# CITY OF ALBUQUERQUE

**Re: Mesa del Sol Community Center Bldg A, No address provided**  
**Temporary Certificate of Occupancy NOT Approved**  
**Engineer's Stamp dated 06/30/08 (R16/DA3005)**  
**Certification dated 12/17/08**

ENGINEER'S CERTIFICATION FOR COMMUNITY CENTER BUILDING 'A' GRADING AND DRAINAGE PLAN

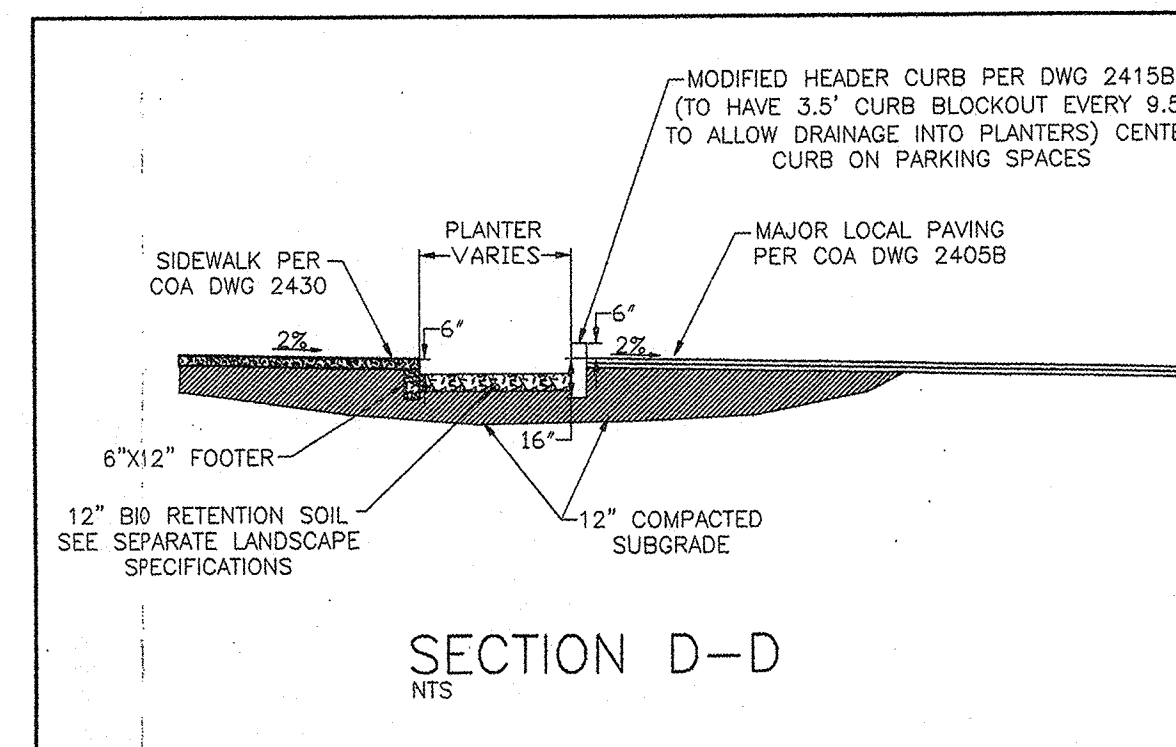
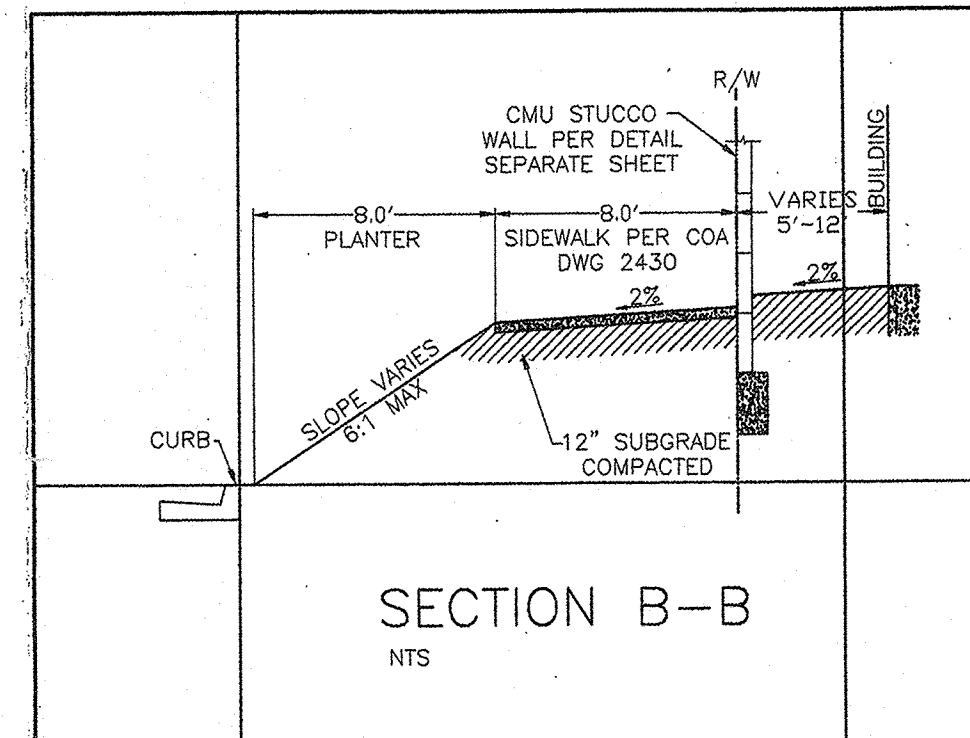
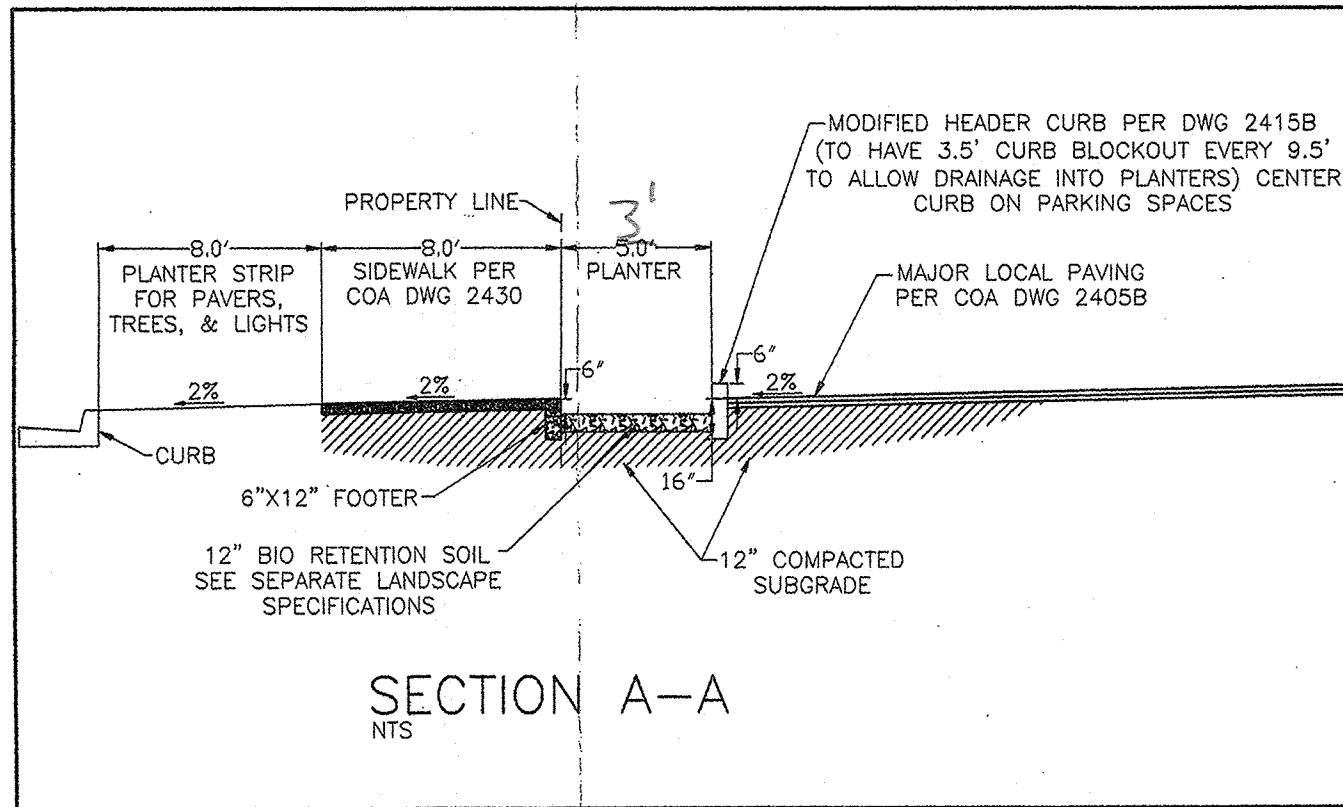
- As noted in the Certification language, the south parking lot drains over the sidewalk because this area was not built per plan. The landscaping area is not depressed and the curb was built around the inlet #4, therefore rendering it nearly useless. This area is required to drain per plan for approval of Temporary or Permanent CO.
- The majority of the site was not available for inspection due to the ongoing construction activity.
- The Certification was done on plan Stamp Date 6-30-08. This plan was approved for Grading Permit not for Building Permit. The plan approved for Building Permit has a Stamp Date of 11-7-07. If you wish to certify the 6-30-08 plan, I can review it and approve it for Building Permit approval. Otherwise you can certify the 11-7-07 plan.
- The Certification should graphically represent the as-built conditions at the site. Mark-up the plan as appropriate.
